Sawbridgeworth Evangelical  
Congregational Church, London  
Road, Sawbridgeworth

Development Management  
Hertfordshire County Council

My ref: EH/19562/2024  
Your ref:  
Date: 17/1/2024

The views of Hertfordshire County Council (HCC) as Highway Authority (HA) have been sought on pre-application access and transport proposals for the refurbishment of the existing church. Demolition of existing 1911 and 1970-90s extensions and replacement with new extension to enhance accessibility and use of the buildings. (No intensification of use intended) at Sawbridgeworth Evangelical Congregational Church, London Road, Sawbridgeworth, CM21 9EH. London Road is designated as a Principle A Main distributor road, subject to a speed limit of 30mph and is highway maintainable at public expense.

Figure 4: Proposed site plan

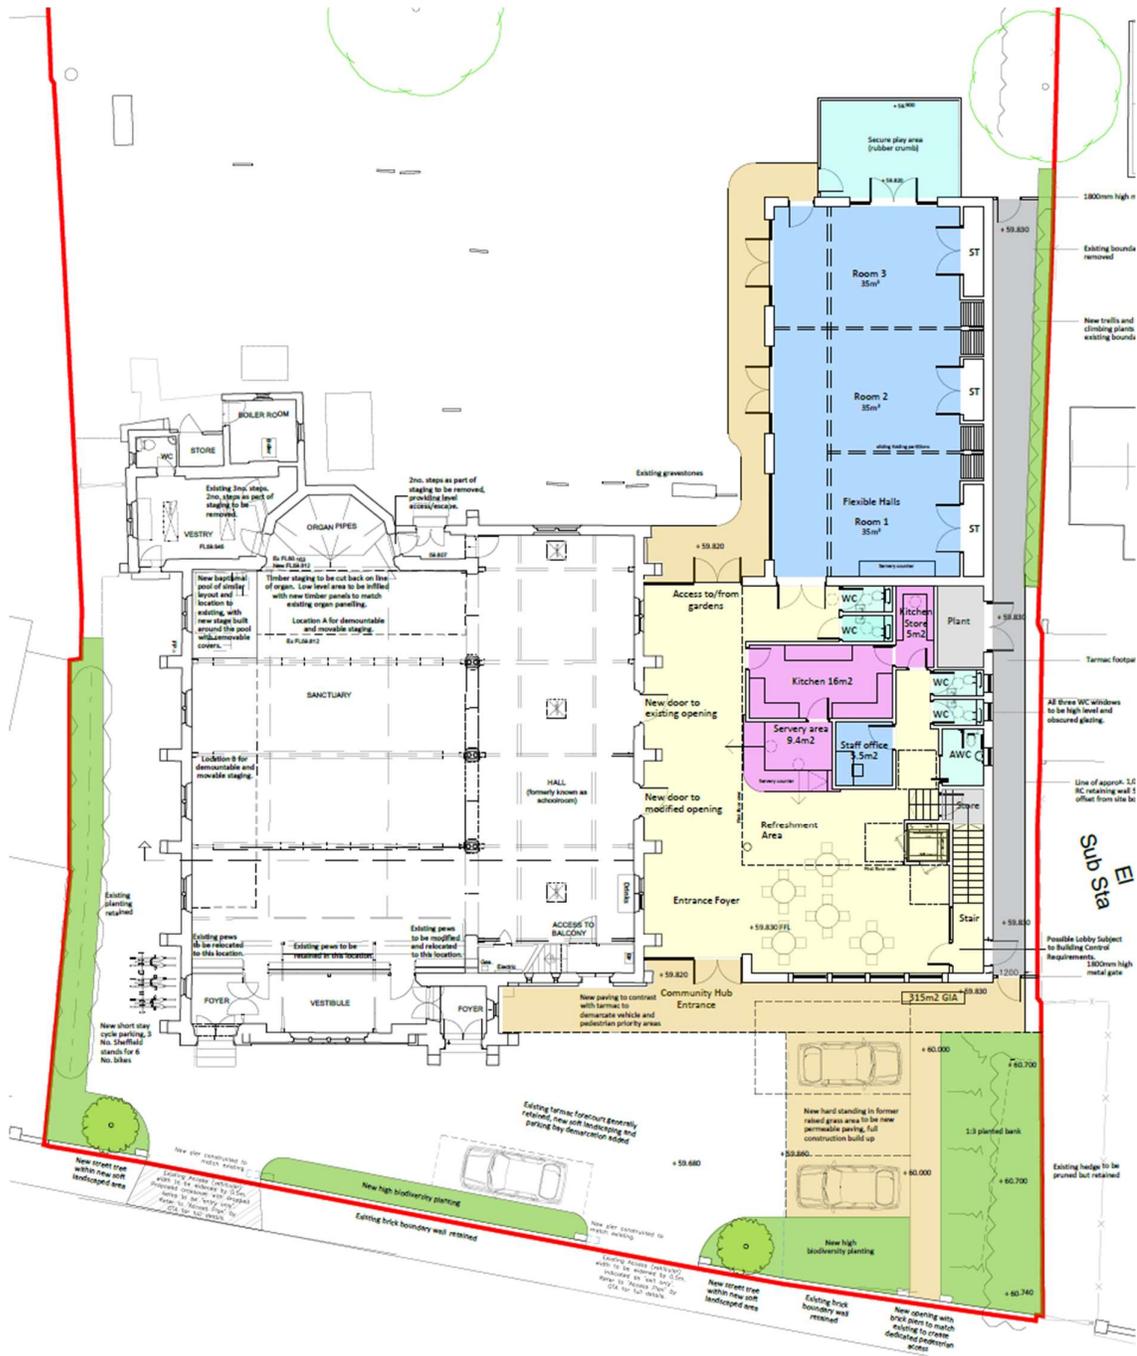
The proposal at this stage is for a new dropped to serve one of the existing openings within the wall line which currently is a full height kerb. This has just been stated within the Transport note but at the full planning stage will need to be included within detailed drawings. The dropped kerb should be built to a maximum of 5.4 metres (4 dropped kerbs and 2 risers) Please see Hertfordshire County Councils dropped kerb policy regarding all details for a new dropped kerb. This can be found here;

As per Hertfordshire County Council *Roads in Hertfordshire: Highway Design Guide 3rd Edition, Section 2: Highway Layout and Strategies, Chapter 9: Permitted Road Connections and Frontage Access, Table 2.9.1.1* vehicle entering and exiting any road with a classification of more than a secondary distributor (in this case a principle A main distributor) will require vehicles to be able to turn on site to enter and exit the highway network in forward gear. This will need to be shown on a swept path drawing to ensure that for the classification of London Road, this can be achievable. This is needed for all spaces and shown in relation to the new dropped kerb.

Finally, visibility splays should be provided for the two accesses. As per a 30 mph road these measurements should be 2.4 x 43 metres in each direction to ensure safety when entering and existing the site.
